Our ref: NO/2013/105444/01-L01
Your ref: 3/2013/0610
Date: 13 August 2013

**PROPOSED SLURRY LAGOON (RETROSPECTIVE)
WITHGILL FARM, WIGHILL FOLD, WITHGILL, CLITHEROE**

Determination of Permeability in a Triaxial Cell

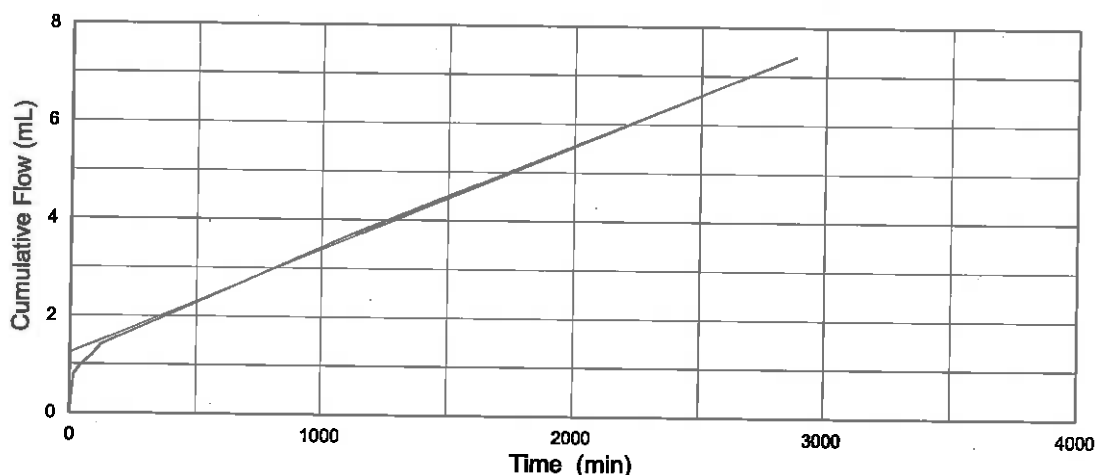
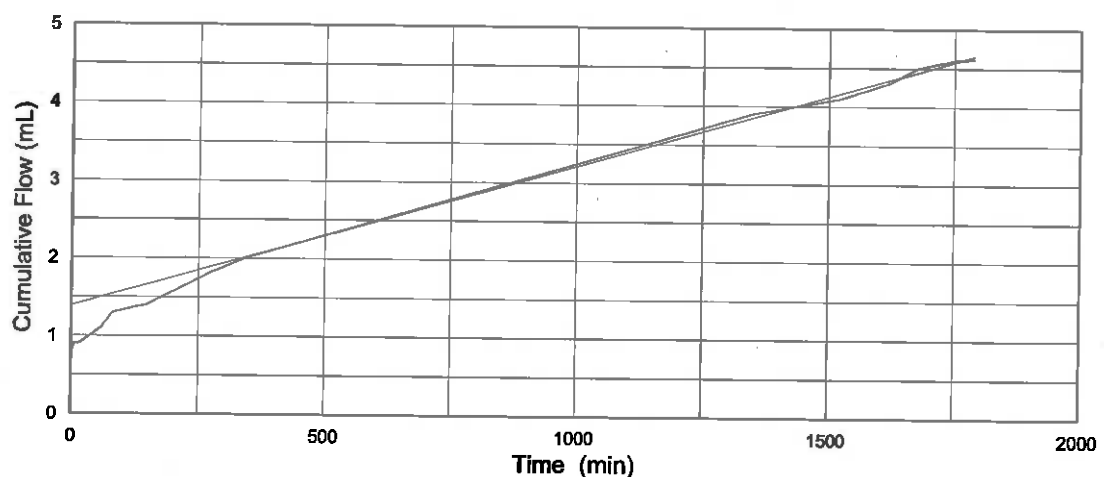
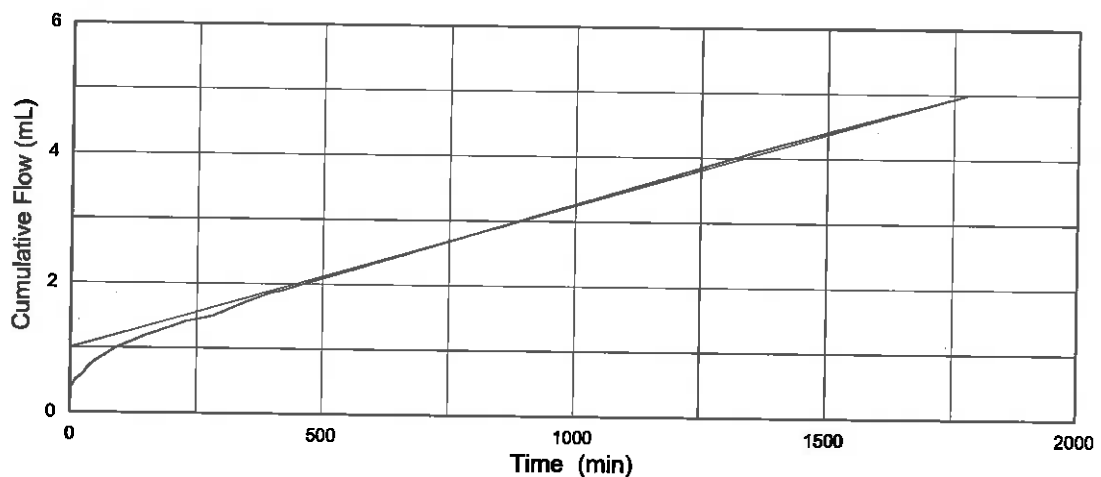
Three permeability tests have been included in the submitted Design & Access Statement and they suggest that the tested material is of suitable permeability to be used in the lining of an earth banked slurry lagoon. However, there is no information on the location where these soil samples were taken or the depth at which they were taken within the soil profile. No information has been submitted to demonstrate the consistency of the deposits across the site (for example, trial pit logs). No information has been provided to demonstrate that the clay is present to a depth of 1 metre below the proposed base of the lagoon.

detail demonstrating that the material up to 1 metre below the base of the lagoon, a suitably low permeability and consistency shall be submitted to the local planning authority for approval. Where this cannot be demonstrated, the applicant will need to submit a scheme for lining the lagoon with an impermeable material to the local planning authority for approval. The development shall proceed in accordance with the approved detail.
